This comment has been submitted in response to the proposed building project at **21 Darnley Close** located on the spur lane of Darnley Close. Concerns have arisen due to damage and disruption that has occurred in the past due to home improvement work on the spur lane. Had the previous project been managed properly the damage and disruption could have been avoided. Hopefully, informing Mr McNulty of the damage and disruption that occurred before he became a resident will enable him to manage his project so that his contractors understand that damage and disruption are unacceptable and will not be tolerated.

Proposed Site Layout
Scale 1:500

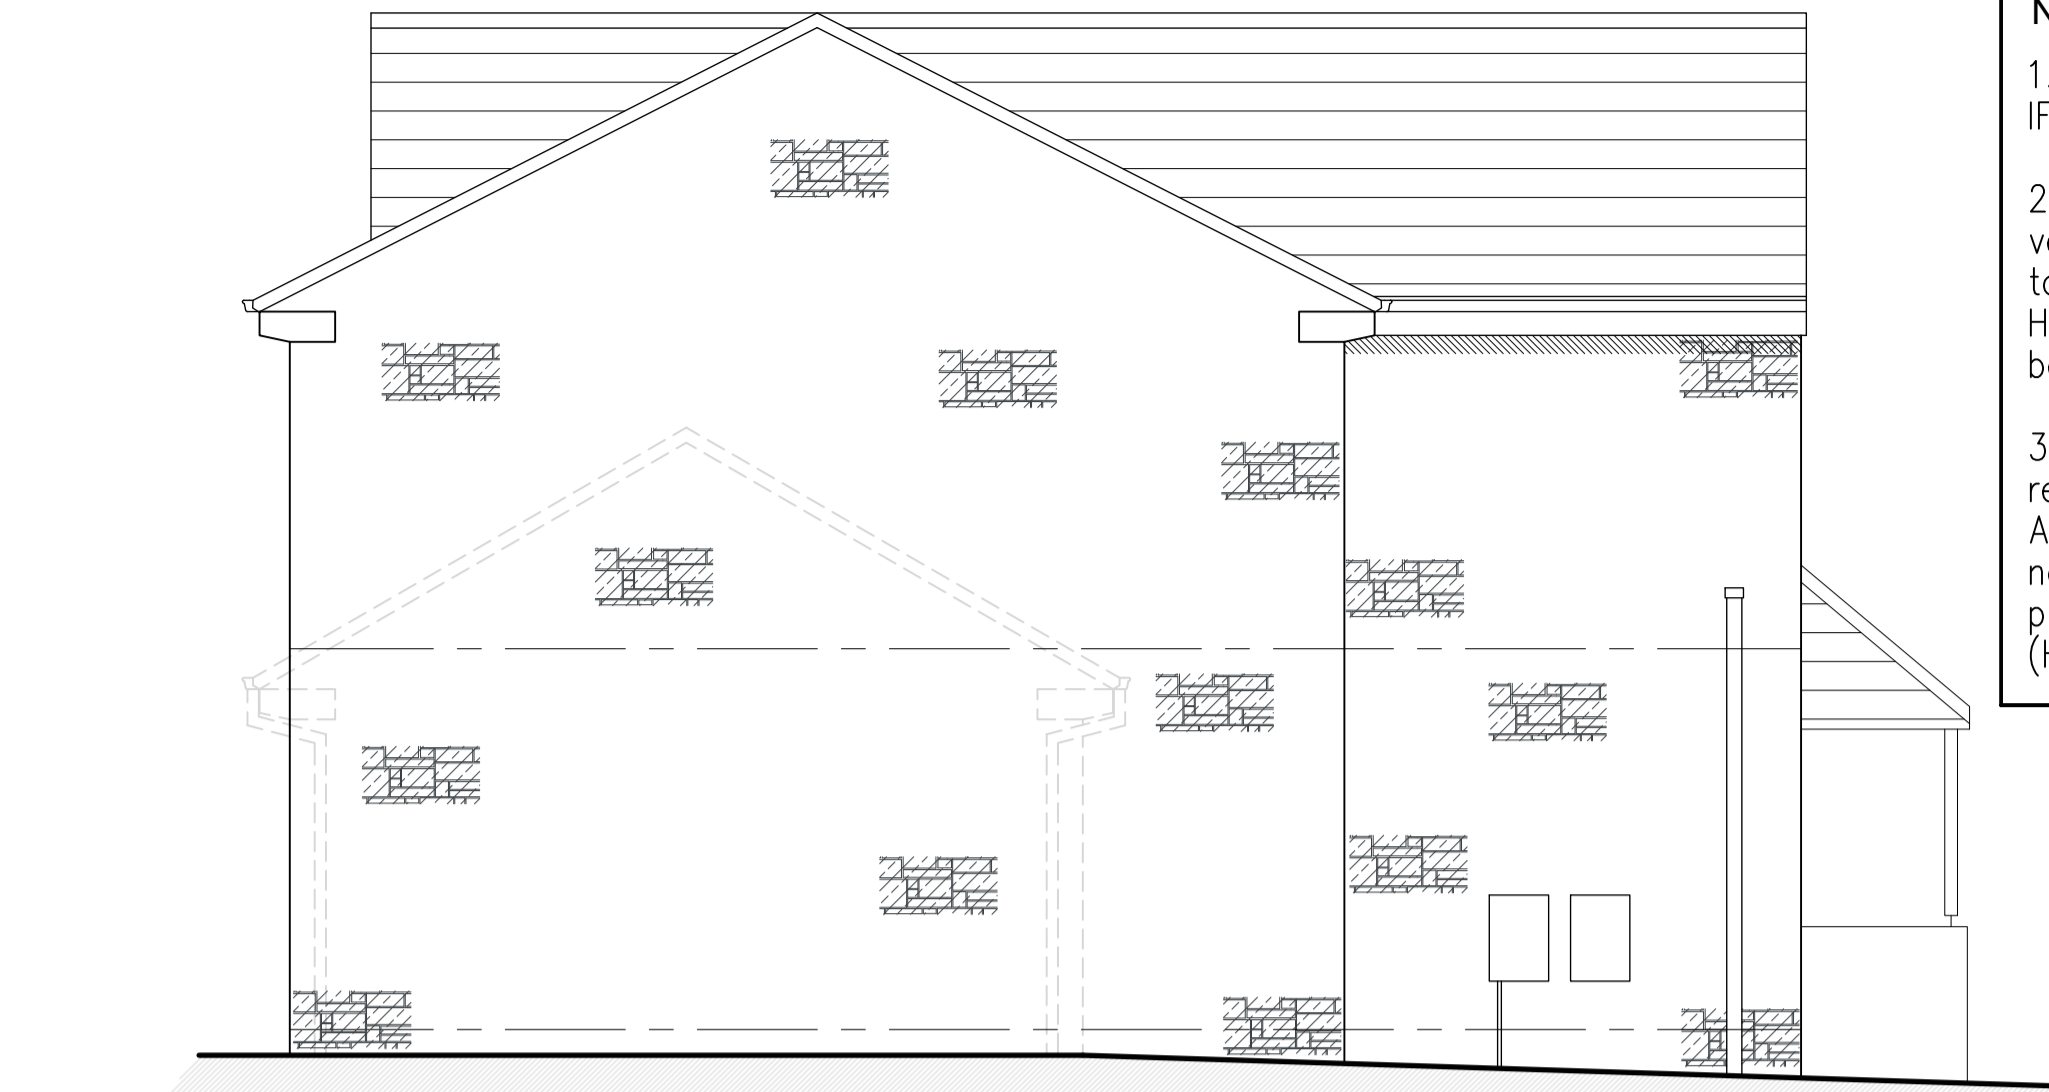
This illustrates some of the issues that have occurred in the last 2-3 years as detailed in this submission. The image shows the garden area of No 23 that borders the lane. It does give a false impression as to the actual width of the lane in front of number **23** and the amount of space in front of numbers **21** and **19** for vehicles to manoeuvre in. The lane is not suitable for access by large vehicles, such as scaffold trucks, cement/concrete trucks, building supplier HIAB trucks etc. The current turning area would also be unsuitable for this type of vehicle as they will not be able to manoeuvre without causing damage to surrounding properties. The turning area outside 21 will be reduced with the proposed building work and it will affect how number 19 accesses their garage area

The  indicates the turning area in front of **19** and **21** after the proposed building work. It will be reduced in size and create the possibility of damage to neighbouring property when vehicles larger than a car or small transit van try to turn around. Access to **19** would be blocked by any car parked in the turning area.
